**Our ref:** AN/2026/137416/01-L01  
**Your ref:** H16-1191-25  
**Date:** 30 January 2026

**Demolition of redundant commercial buildings and the erection of 5 dwellings  
39-41 Albert Street, Spalding, PE11 2LD**

PROPOSED STREET SCENE

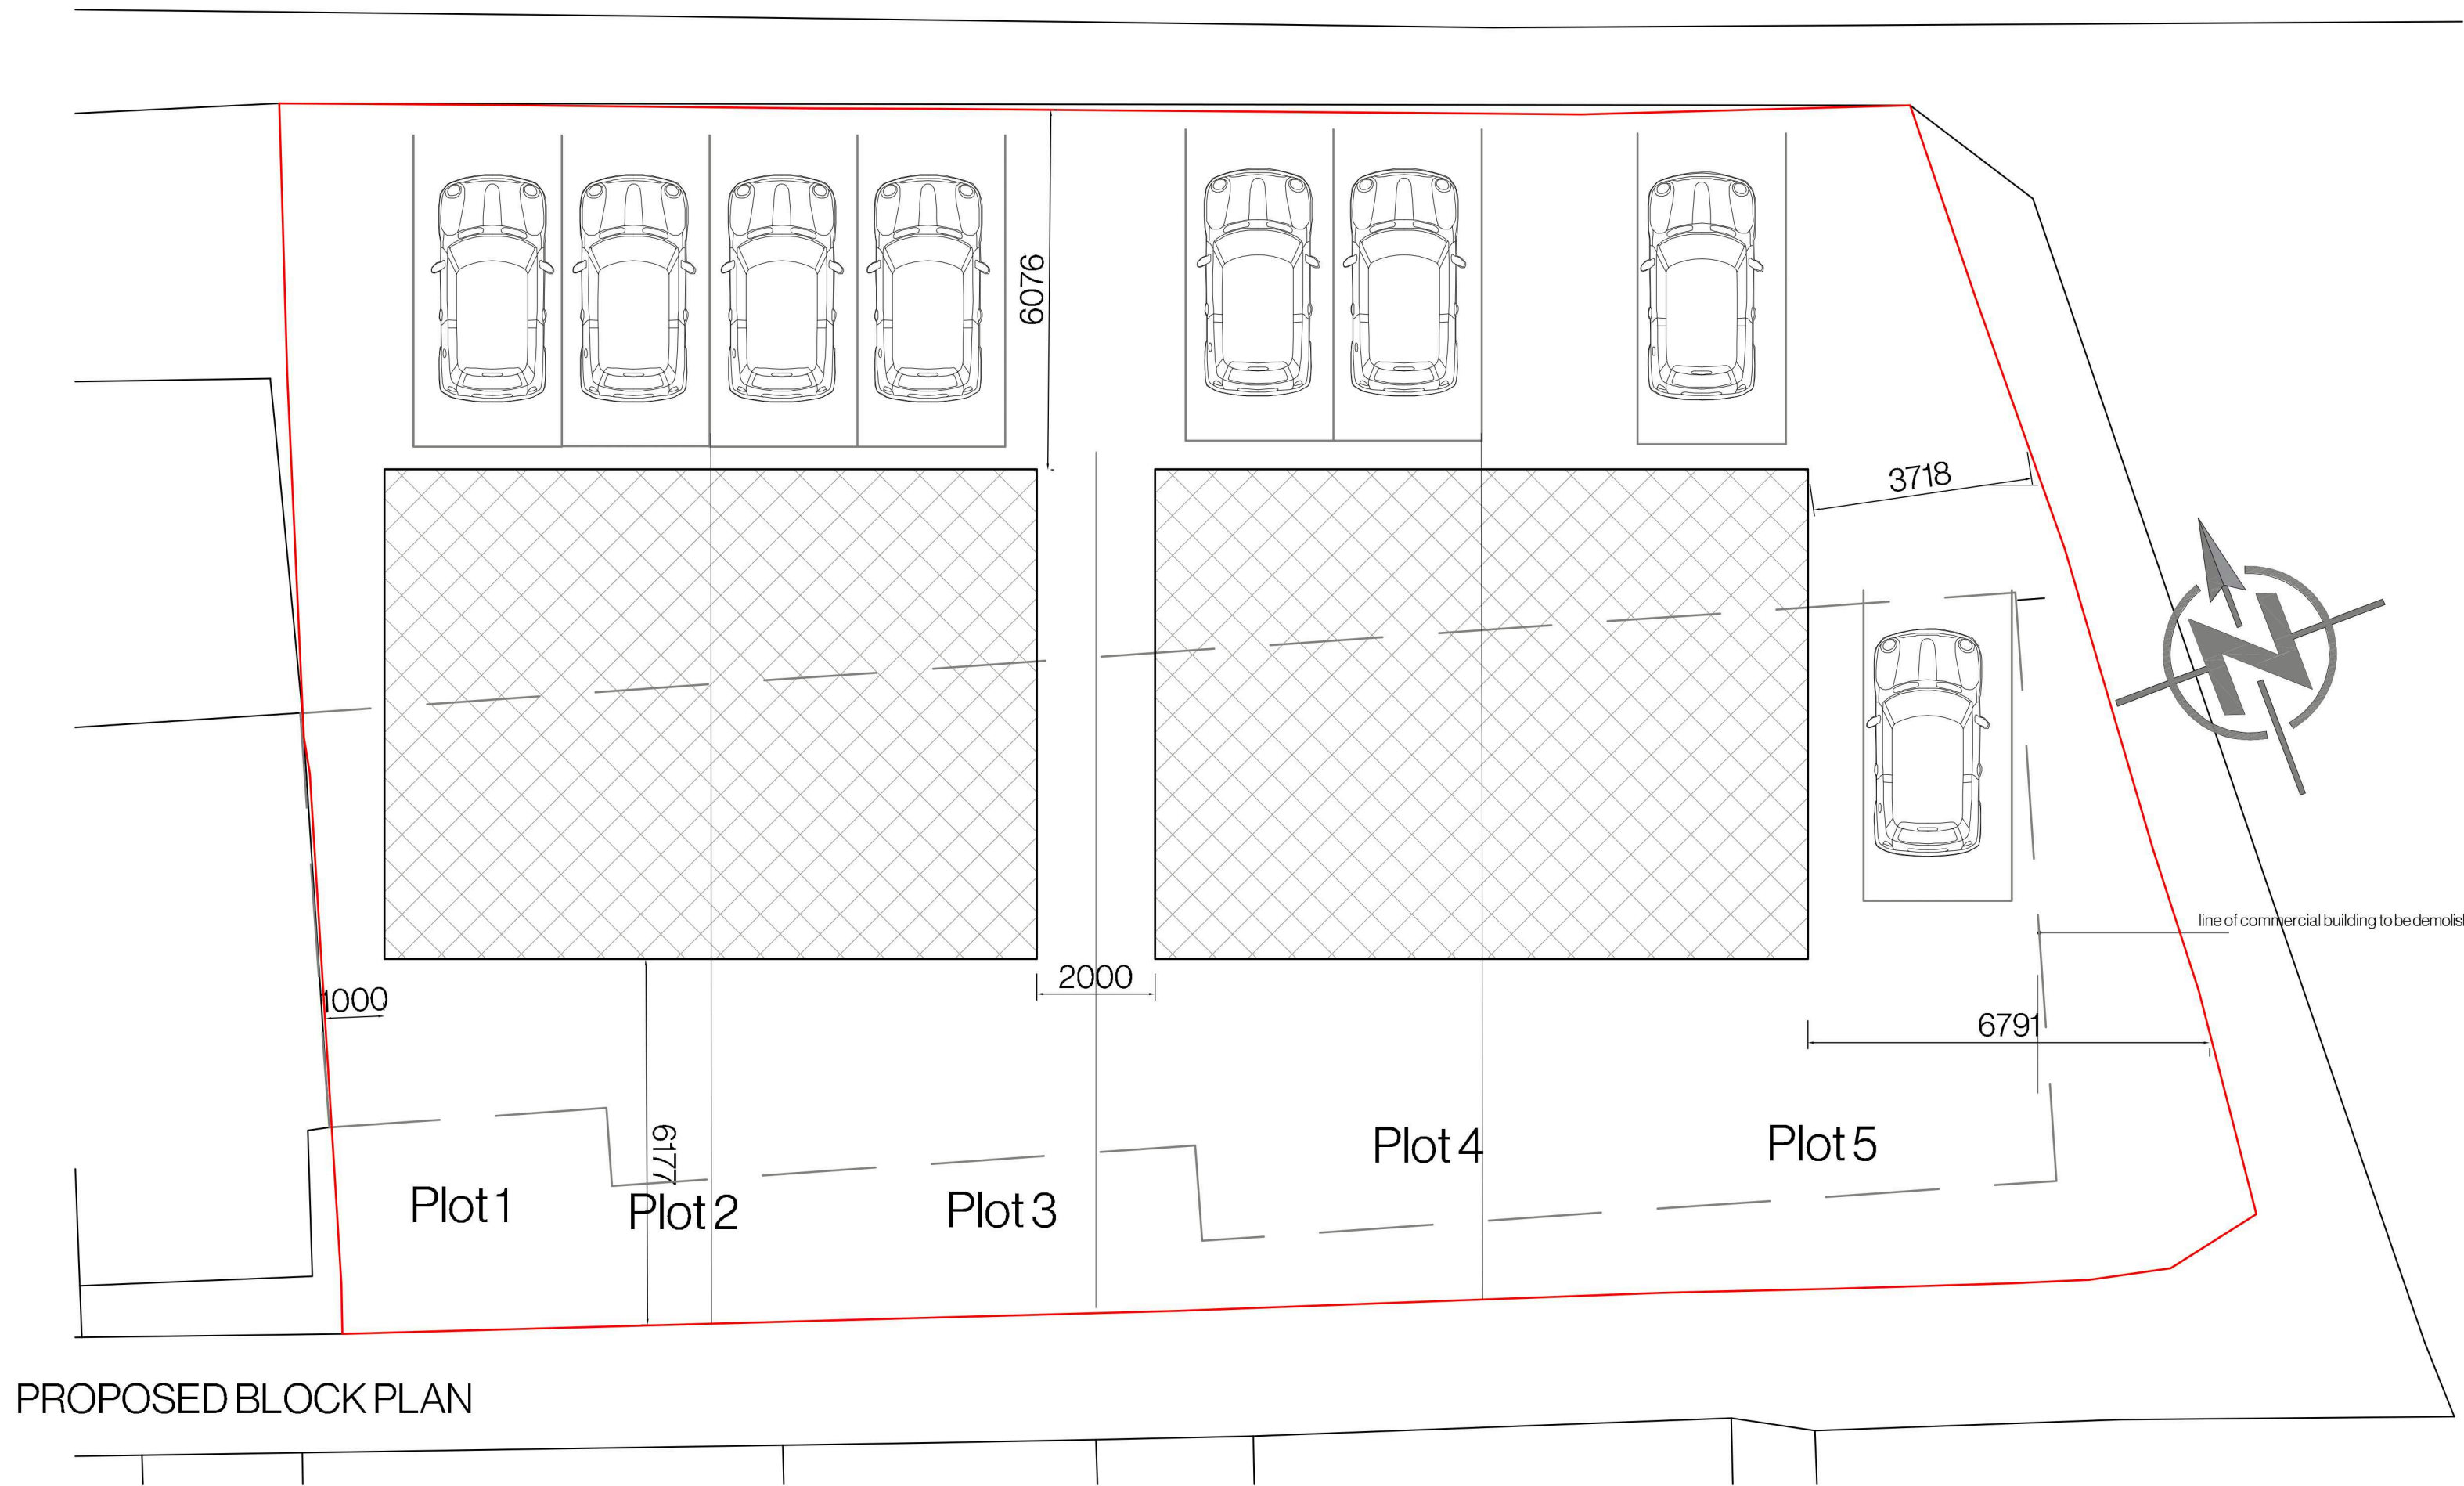
We note that the submitted FRA does not explain how the finished floor levels of the dwellings are intended to be achieved. The submitted elevation drawings do not suggest that the floor levels will be achieved through the building design, nor do they denote that the ground levels across the site will be raised.

- Finished floor levels shall be set no lower than 1.0m above existing ground level, equivalent to 4.65mAOD
- The dwelling shall be a minimum of two storeys.
- Flood resilient construction shall be incorporate to a minimum of 0.3m above Finished Floor Levels, equivalent to 4.95mAOD
- Demountable defences shall be provided to 0.6m above the finished floor levels
